PR-2023-009380

SD-2024-00010 – PRELIMINARY/FINAL PLAT

CSI – CARTESIAN SURVEYS, INC. agent for **TIRYAKI AND MARTHA AHMET** requests the aforementioned action(s) for all or a portion of: **LOTS 1 THRU 7, BLOCK 3, PANORAMA ADDITION** zoned **MX-M**, located at **SW CORNER OF SAN JACINTO AVE AND GEORGENE DR NE** between **COPPER AVE NE and CONEJO RD NE** containing approximately **0.4824** acre(s). (**K-22**)

REQUEST: CREATE ONE NEW LOT FROM 7 EXISTING LOTS. PROPOSED PLAT DEDICATES ADDITIONAL RIGHT-OF-WAY AT NE AND SE CORNERS OF PROPOSED LOT FOR SIGHT TRIANGLE.

**Plat for
 Lot 1-A, Block 3
 Panorama Addition
 Being Comprised of
 Lots 1-7, Block 3
 Panorama Addition
 City of Albuquerque, Bernalillo County, New Mexico
 November 2023**

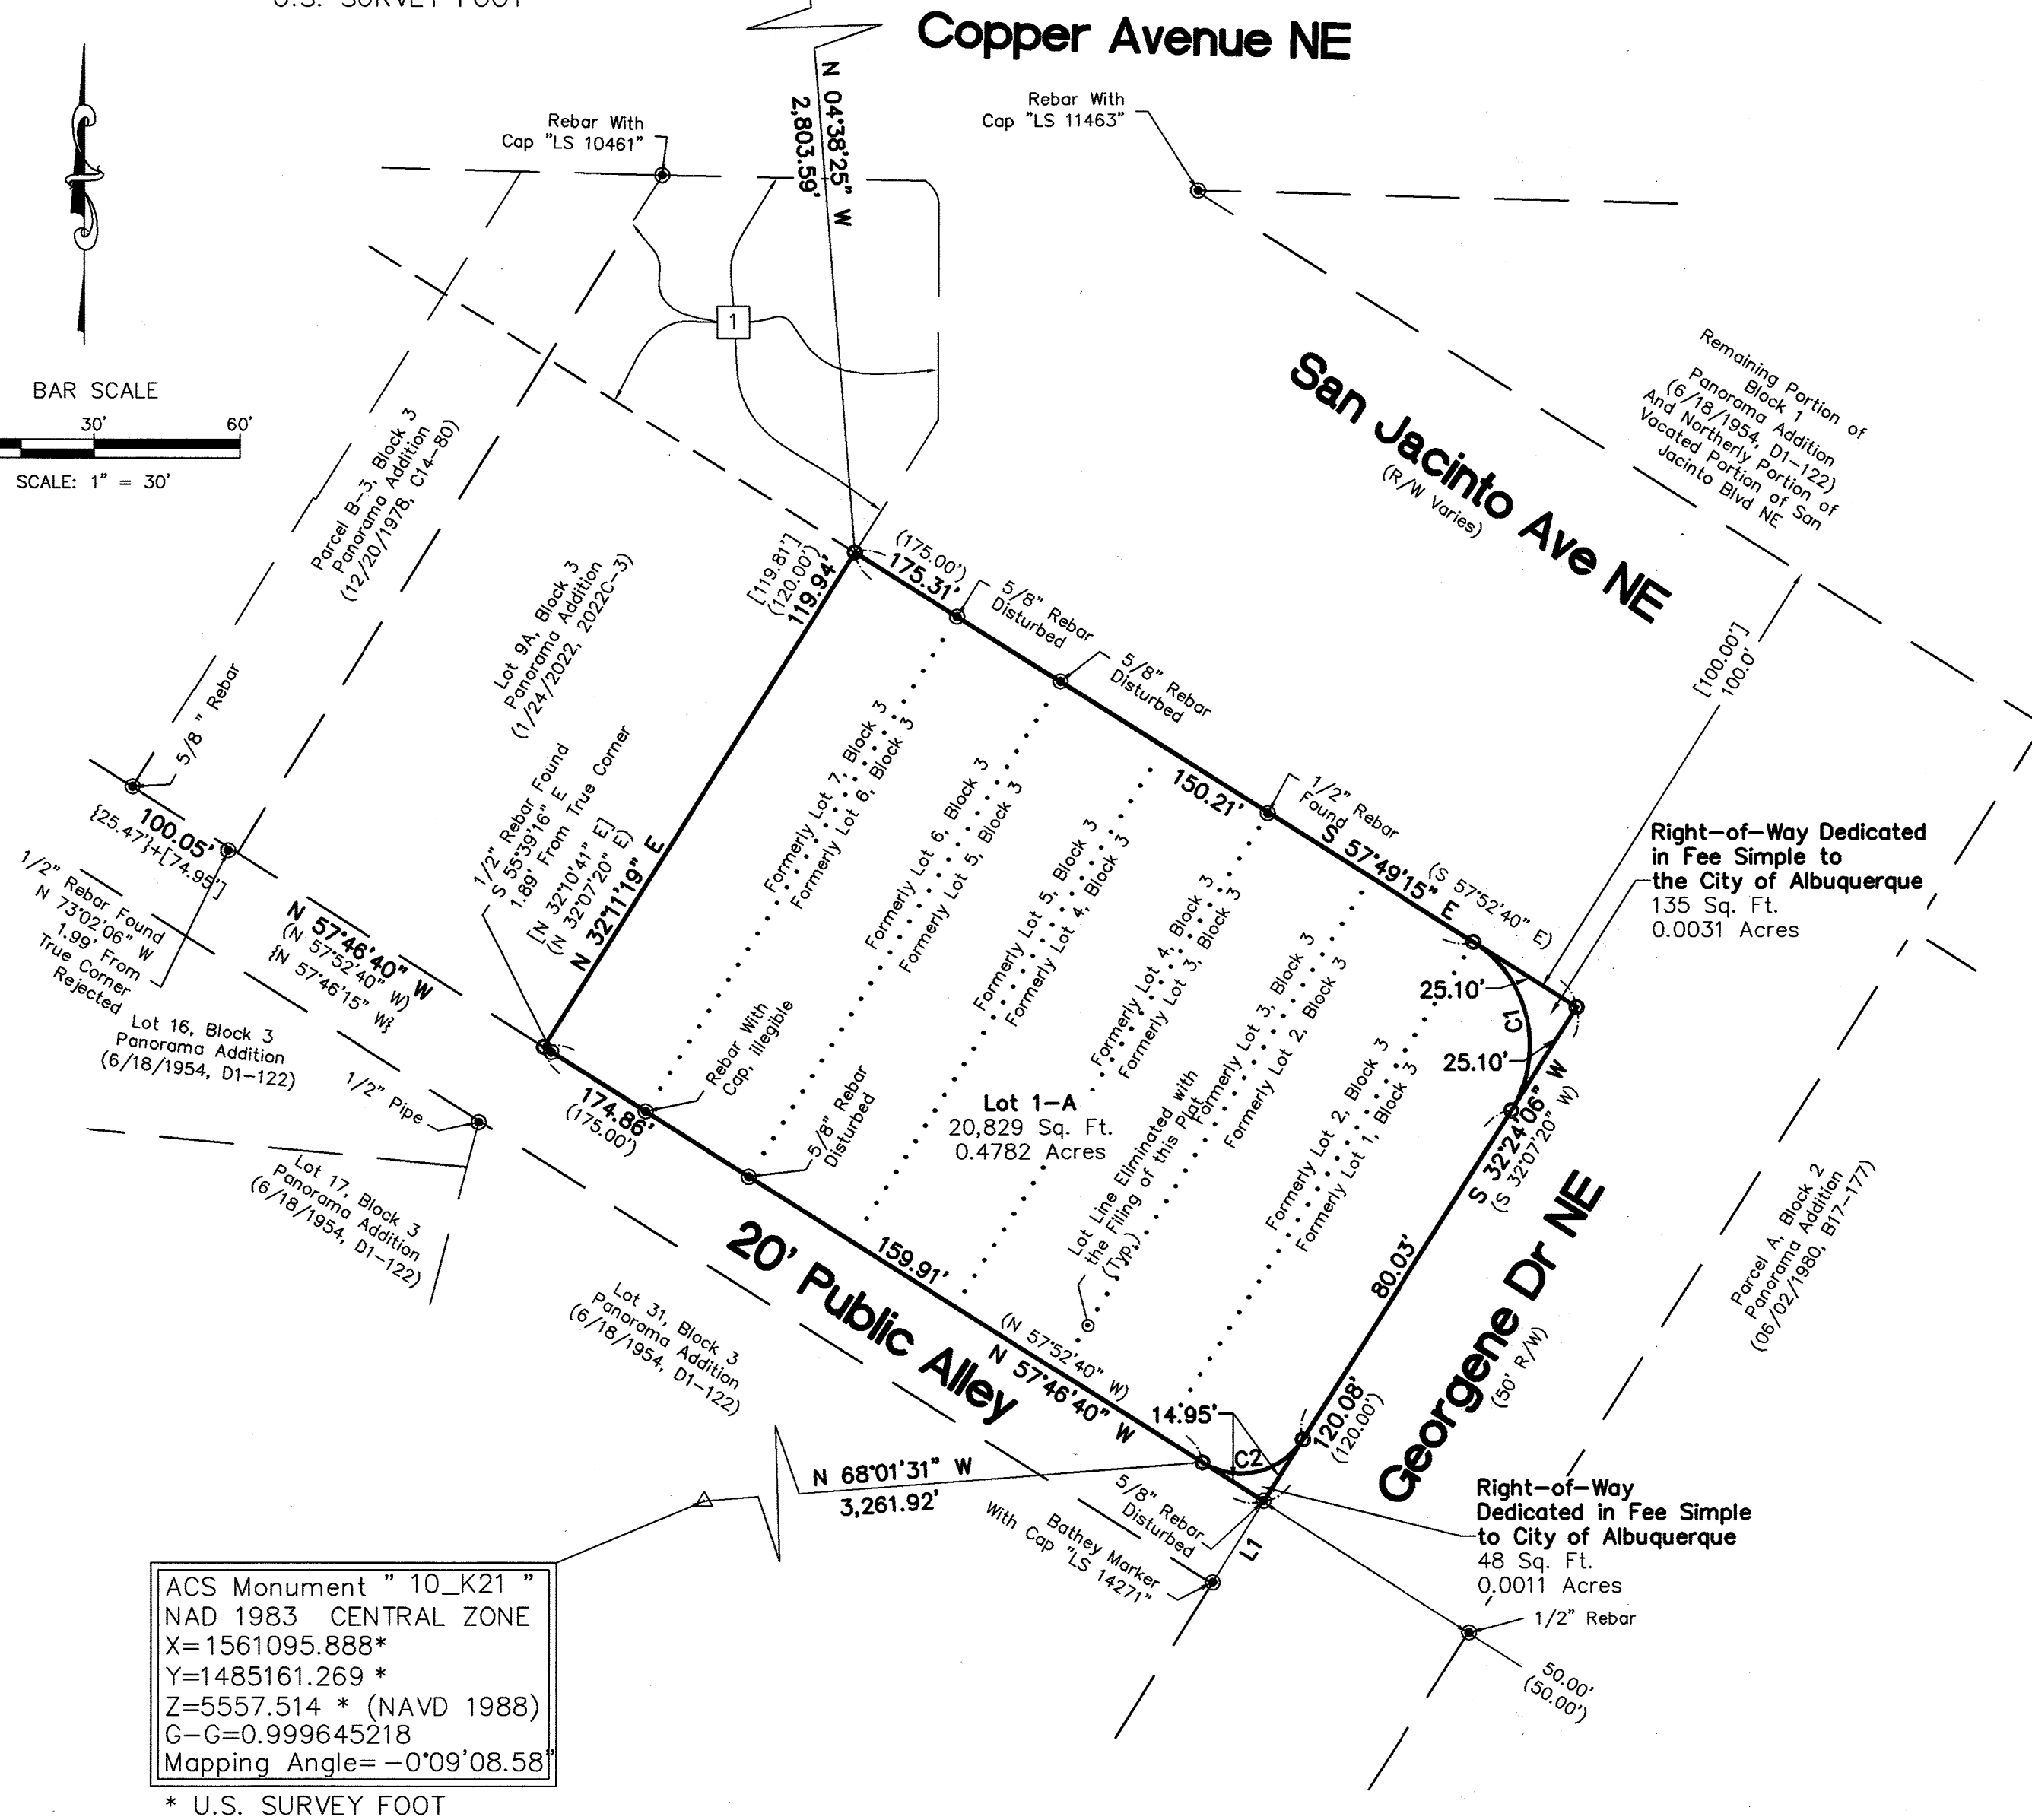
1. Georgene and San Jacinto are both local roads and require 5' sidewalks with a 4'-6' landscape buffer. The sidewalk along Georgene is adequate, and the sidewalk and buffer called out in the Infrastructure list for San Jacinto is adequate, but there is no landscape buffer shown for Georgene nor is there one on the Infrastructure list. You will need to provide the landscape buffer along Georgene or request a waiver with a justification letter.

- Demonstrate compliance with **section 7 of the DPM Table 7.2.29** and Required Improvements section from 5-4(N) of the IDO. *Regarding Sidewalk width requirements and the landscape buffer. Provide measurement for the existing ROW and distance from curb to property line along street frontages. ***Verification of standards per Transportation***
Georgene and San Jacinto are both local roads and require 5' sidewalks with a 4'-6' landscape buffer. The sidewalk along Georgene is adequate, and the sidewalk and buffer called out in the Infrastructure list for San Jacinto is adequate, but there is no landscape buffer shown for Georgene nor is there one on the Infrastructure list. You will need to provide the landscape buffer along Georgene or request a waiver with a justification letter.
